Comment for planning application 23/00501/REM

Application Number	<input type="text" value="23/00501/REM"/>
Location	<input type="text" value="Unit 2 Kalabergo Close Banbury OX17 2FJ"/>
Proposal	<input type="text" value="Reserved matters application & condition discharge of Part B of 19/00128/HYBRID - Part B: Outline planning application - the development of up to 2 no. commercial buildings having a maximum floorspace of 16,890m2 and having a flexible use [to enable changes in accordance with Part 6 Class V of the Town and Country Planning (General Permitted Development) Order 2015 (as amended)] within Class B2 or B8 of the Town and Country Planning (Use Classes) Order 1987 as amended, and ancillary Class B1 offices, with all other matters reserved for future approval (19/00128/HYBRID)"/>
Case Officer	<input type="text" value="Lewis Knox"/>
Organisation	<input type="text" value=""/>
Name	<input type="text" value="Catriona Reid"/>
Address	<input type="text" value="Dunlea, Main Street, Hanwell, Banbury, OX17 1HL"/>

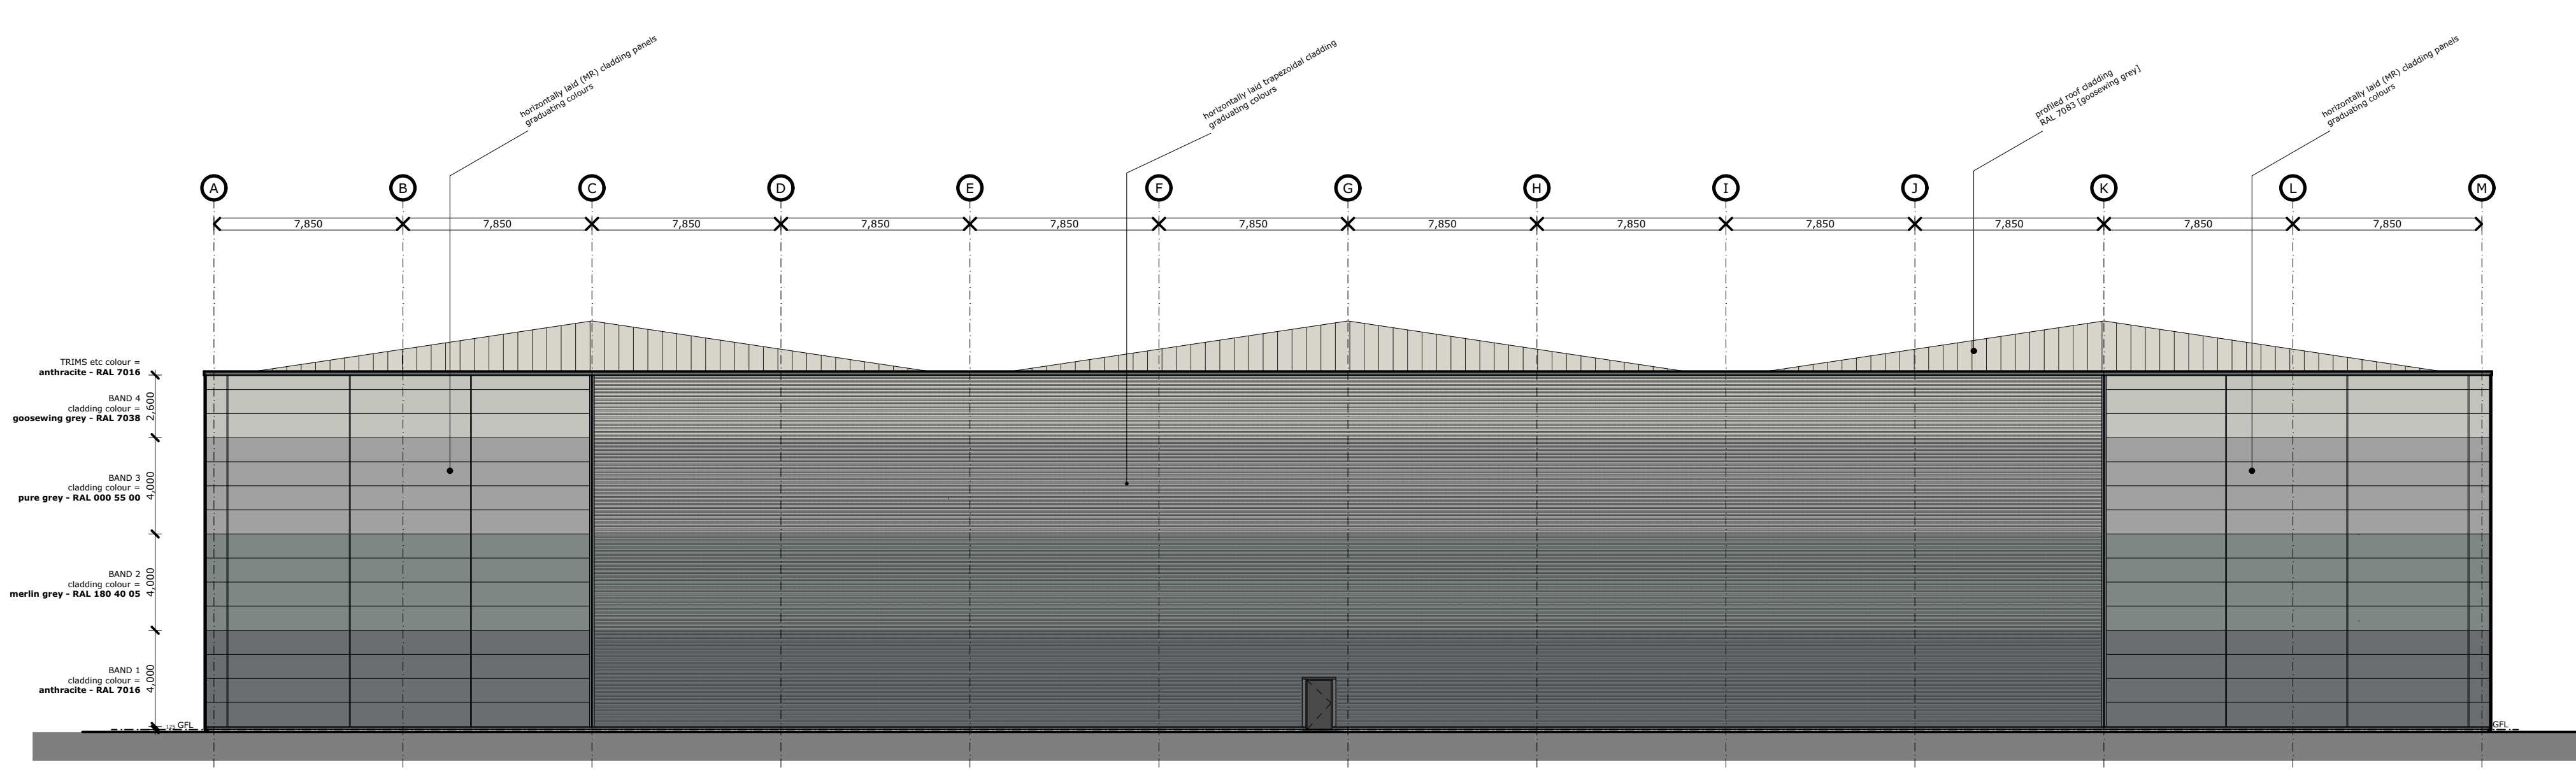
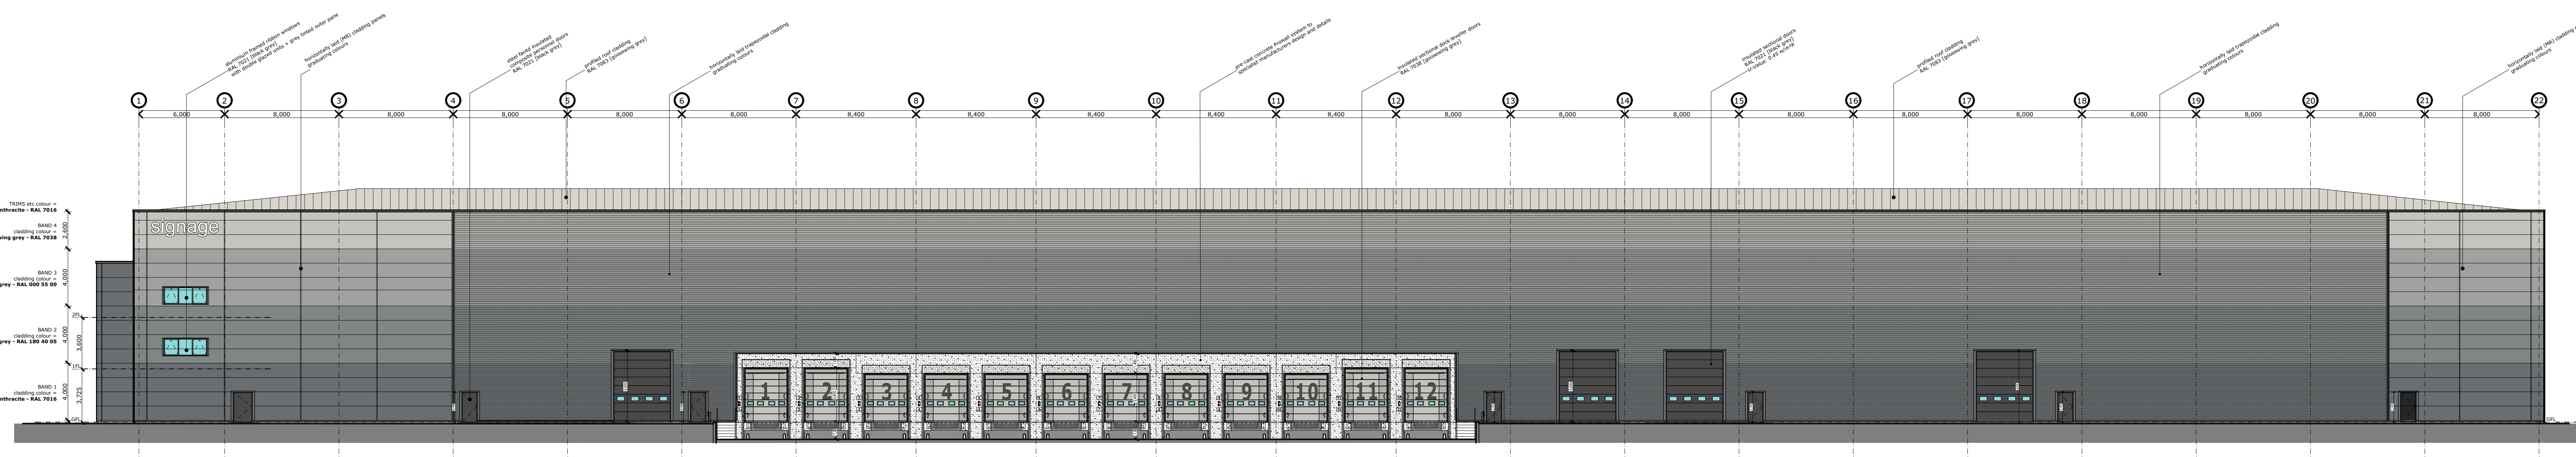
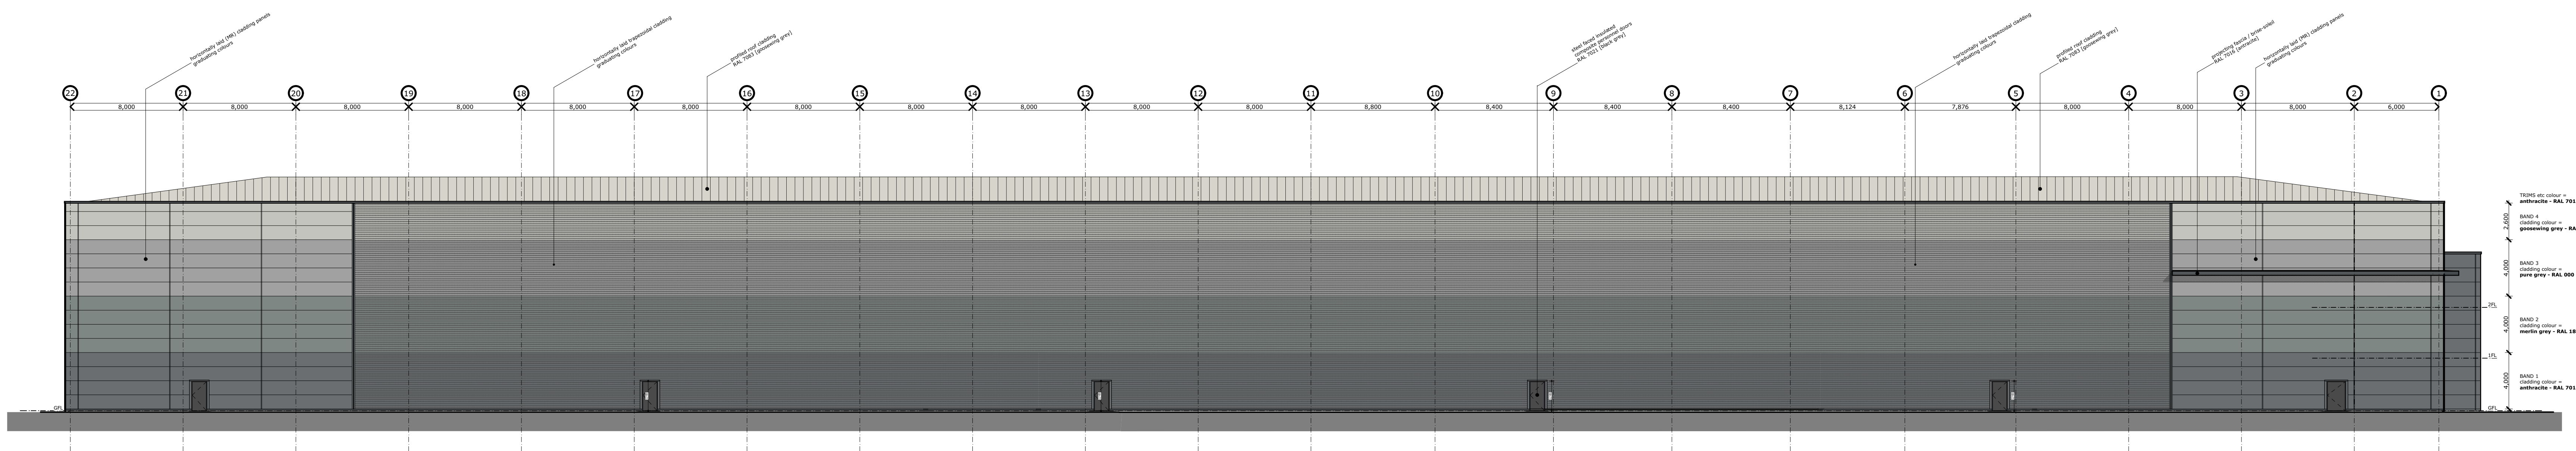
Type of Comment	<input type="text" value="Objection"/>
Type	<input type="text" value="neighbour"/>
Comments	<input type="text" value="I object to the overall proposal. Specifically though I do not think it is fit for modern purpose. There is no provision for the production of renewable energy through solar panels on the vast expanse of roof and there is inadequate provision of electric car charging points to reflect the overall societal change."/>
Received Date	<input type="text" value="30/03/2023 22:52:22"/>
Attachments
